CITY OF ALBUQUERQUE

PLANNING DEPARTMENT – Development Review Services

RE: **Longhorn Steakhouse- Retail Center** **DB13-D003A2**
9975 Coors By-Pass NW PE Stamp dated: - N/A
Conceptual G & D Plan for Administrative Amendment to Site plan

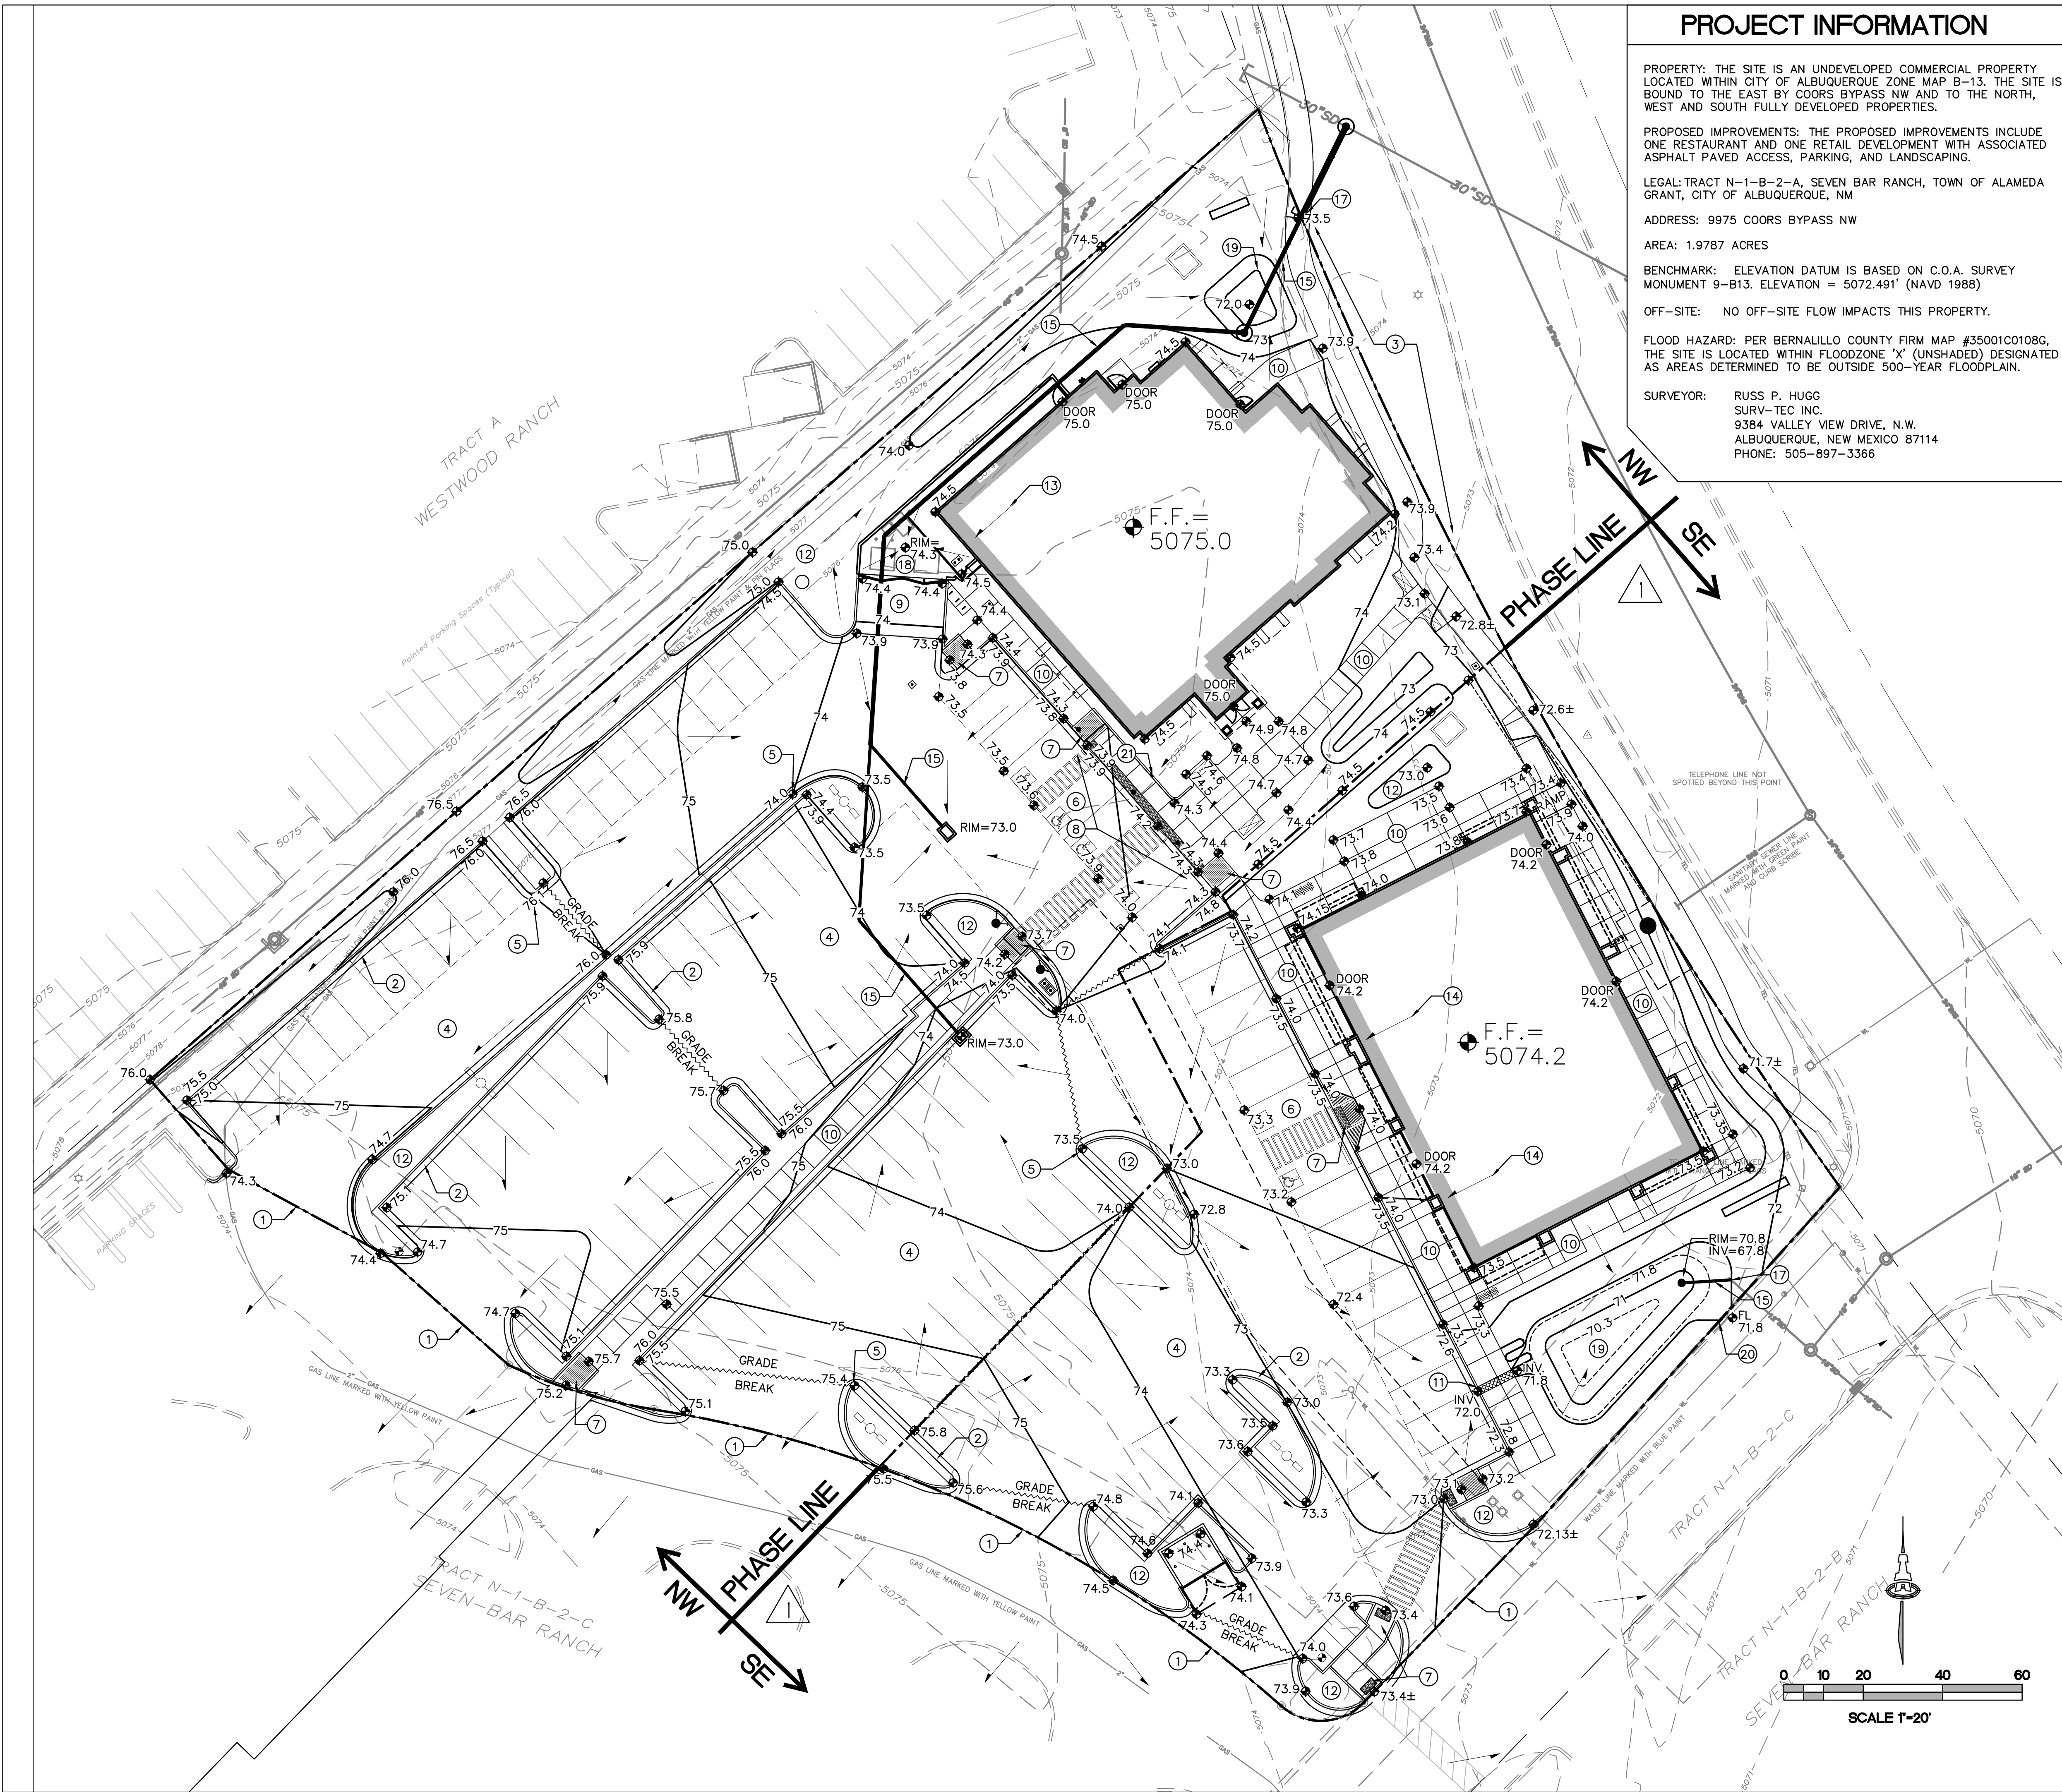
- This plan differs from previous grading layout, in that it proposes to discharge a portion of the runoff from the northern corner of the site to an existing Storm Drain Manhole which is located on the neighboring property. The existing Grading Plan routes your Basins 2 and 3 to the Coors Blvd. By-Pass Storm Drain, at the SE corner of Basin 3. Confirm that capacity exists in the off-site system proposed to be used.
- Our records do not show that the above MH is part of the public storm drain system. The Grading and Drainage plan for that site (B13-D006B) was certified by your office, so hopefully your records can confirm right and capacity for this outfall.
- Your subsequent G&D submittal stamped 8-29-13, expands the area draining to the above MH. We will defer further review of your GP for BP submittal until the Private vs. Public Storm Drain question, and capacity is resolved.

To clarify, the proposed layout of paving and structures appears suitable for site plan amendment, but the Grading Plan issues must be resolved for approval.
